From: Webb, Robert L. <rwebb@cabq.gov>
Sent: Wednesday, September 17, 2025 8:51 AM
To: Andrea Rand
Subject: RE: U-Haul Plat questions

Just a heads up on my Planning comments for the Site Plan.

The Site Plan (3rd submittal) is being reviewed for approval on the current DFT agenda. How is or how will the plat and any infrastructure or dedication of ROW affect the site plan review and approval?

SHEET CONTENTS:
**ALTERNATIVE
RESTORATION
PLAN**

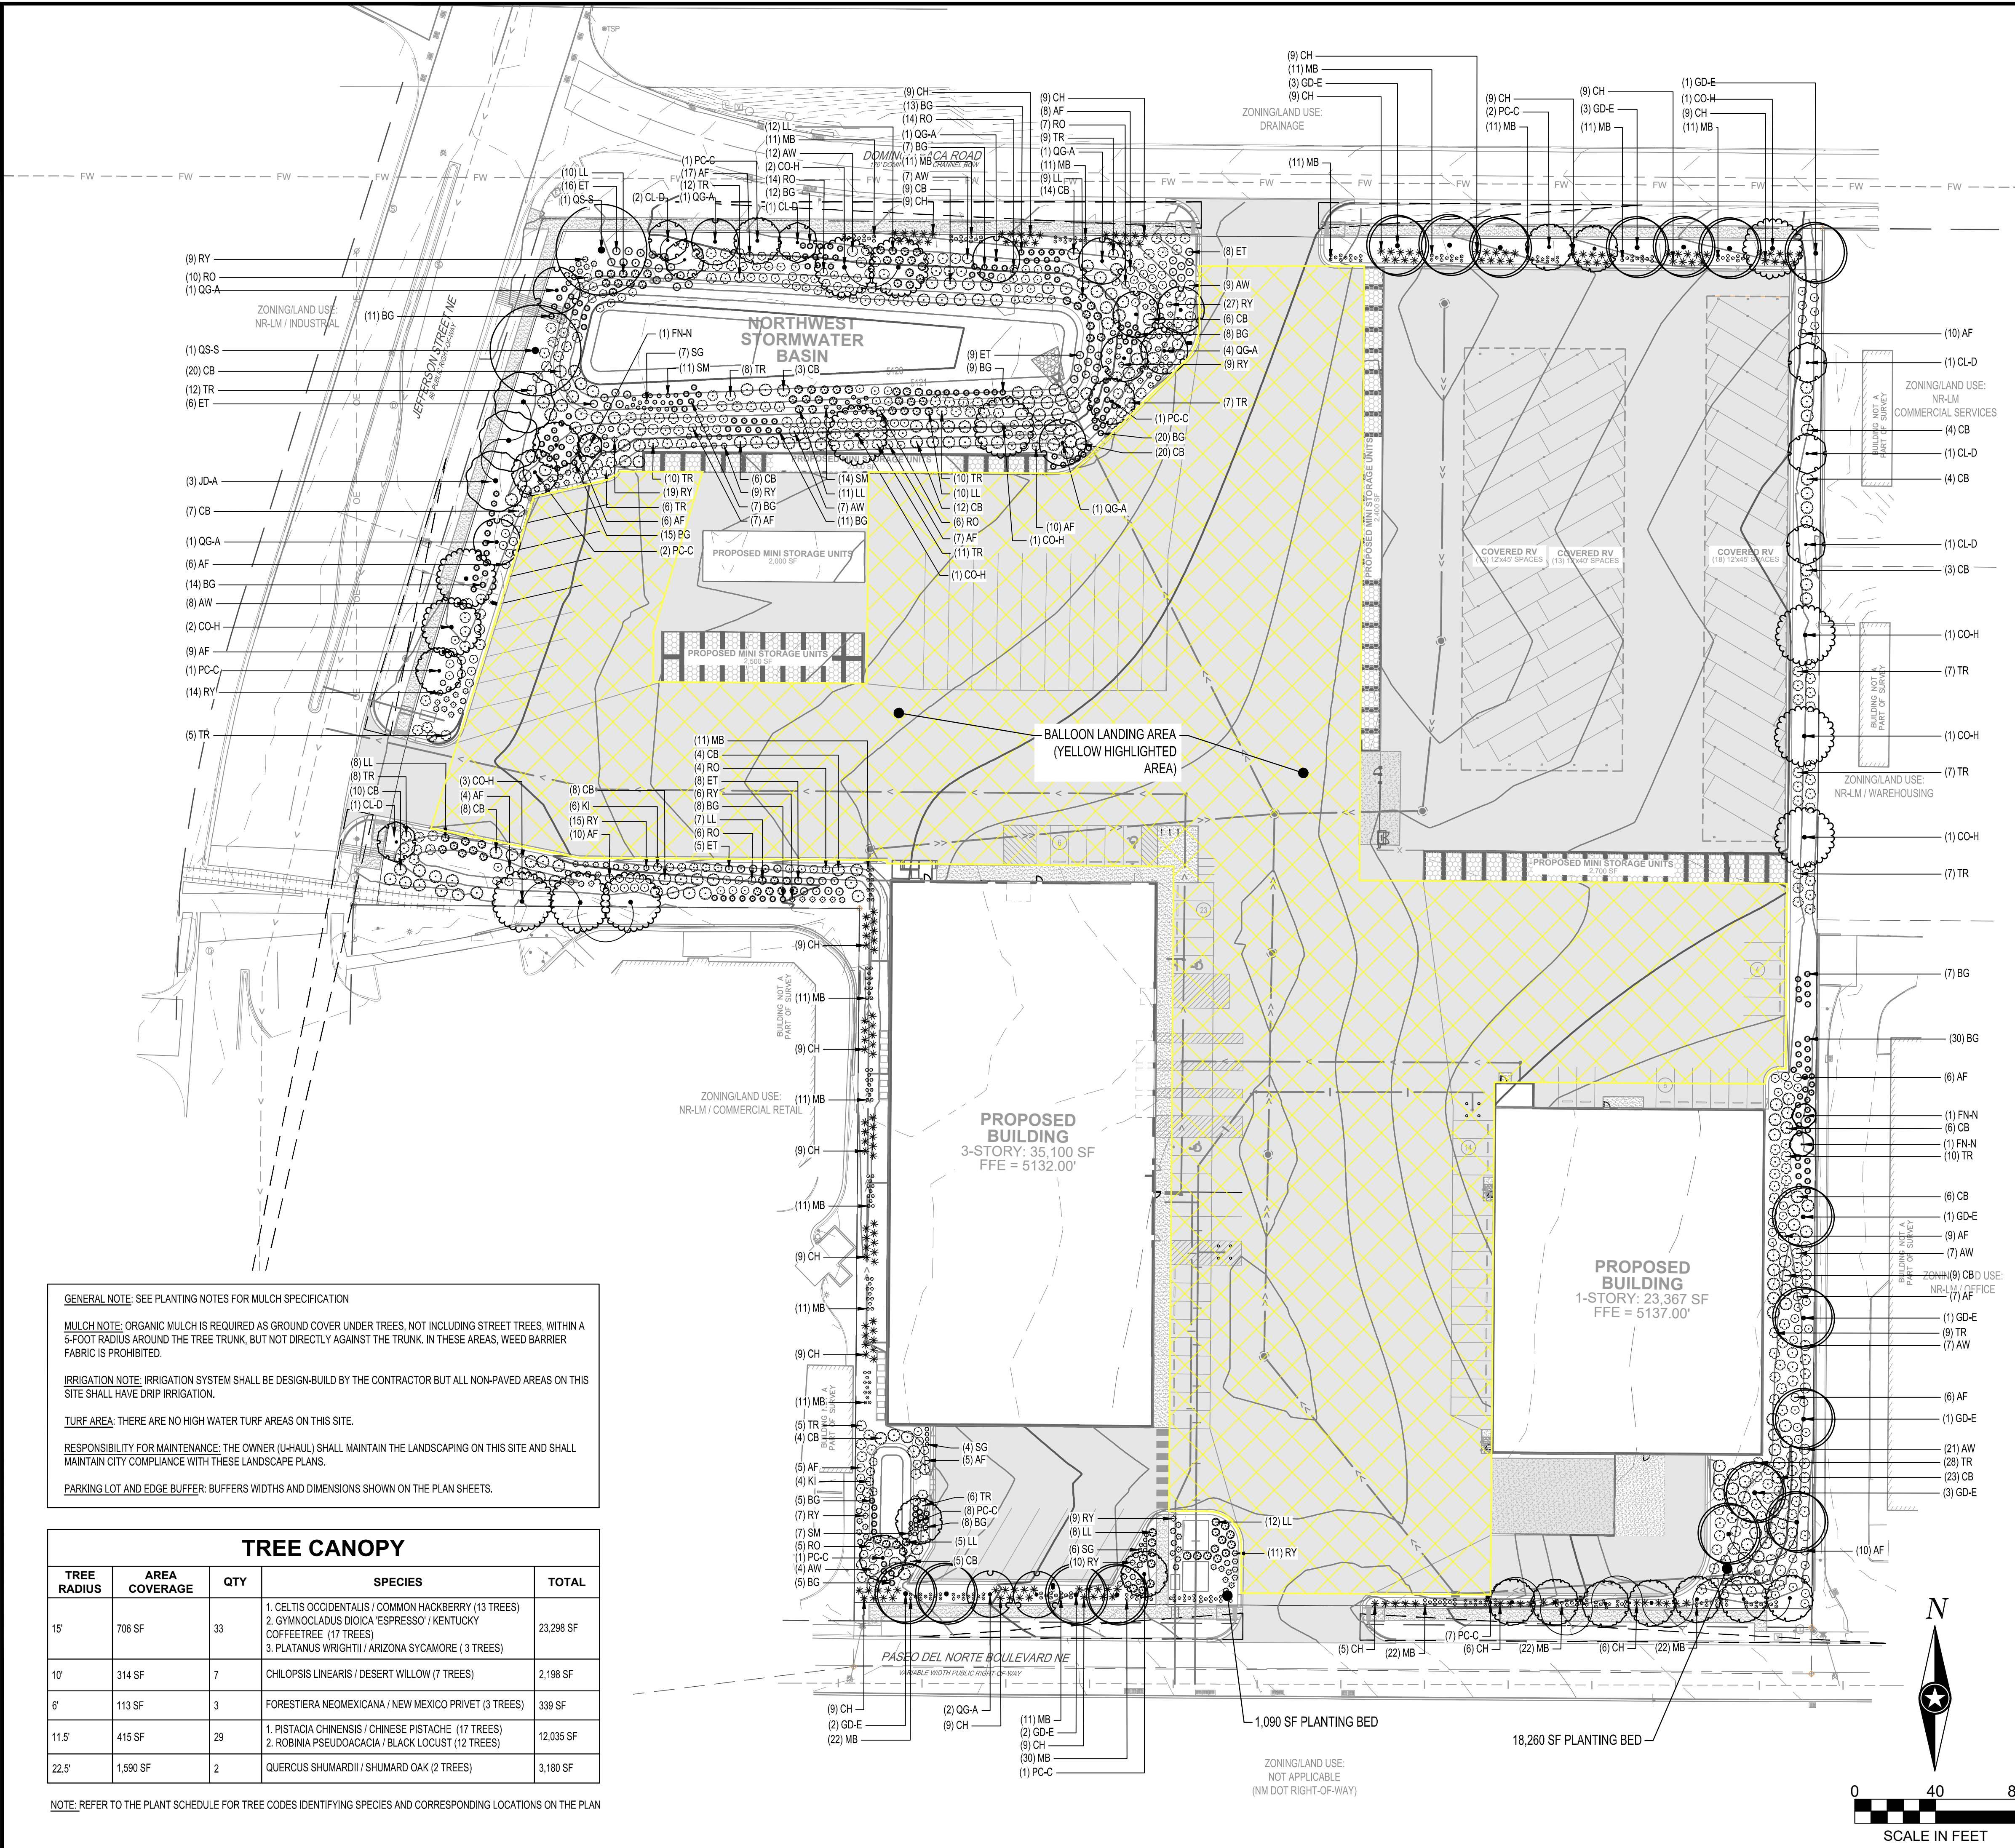
**Clarify the details of meeting 5-11-E-3, #2 (a, b, c, d).*
**Clarify if seating area was included in the landscaping plan, matching the site plan sheets.*

- *Confirm no changes to façade and elevation design from previous submittals.*
- **An Alternative Landscape Plan has been submitted, with a revision recently submitted, and is being reviewed in concurrence with this Site Plan. It had been approved by Planning and Parks staff, and the ZEO is currently providing a final review of the Plan. Confirmation from the ZEO that the Alternative Landscape Plan has been approved is required prior to the approval of the Site Plan Administrative DFT by DFT staff.*

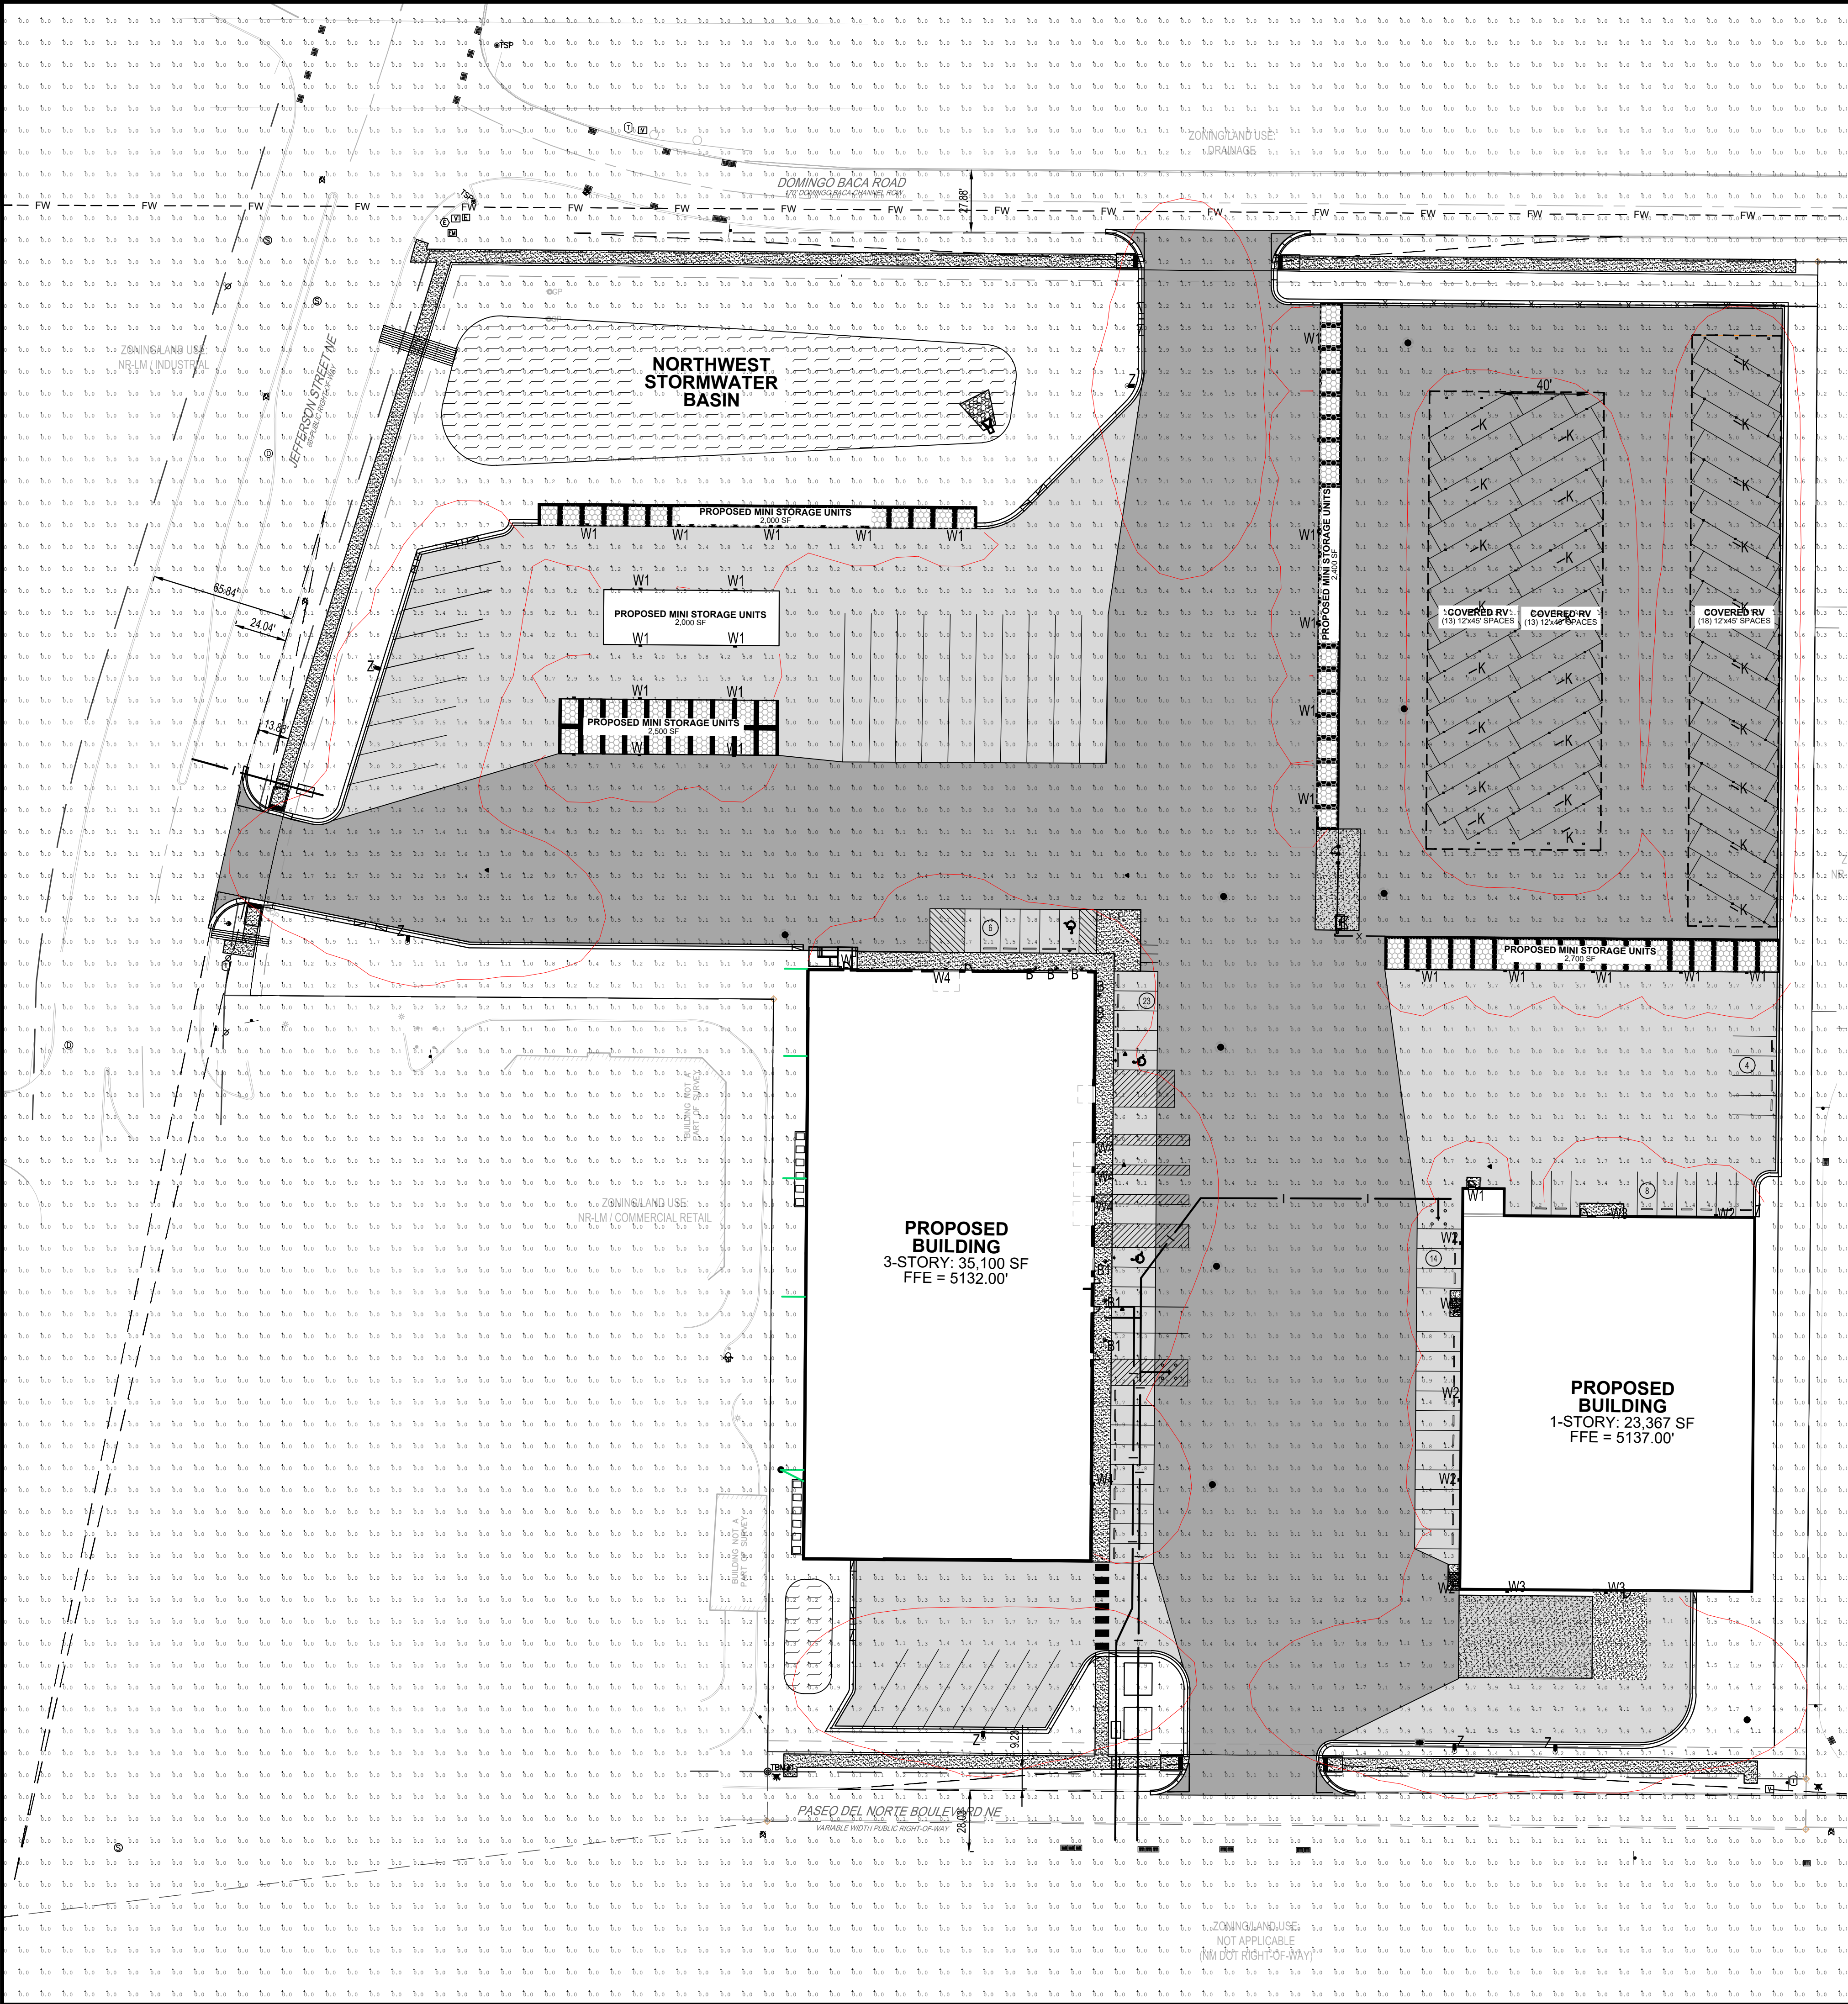
- *Confirm that Code Enforcement has approved the lighting plan, per current standards within IDO section 3-4-K and 5-8.*
- *An outdoor seating area is required for a primary building(s) more than 30,000 s.f.*
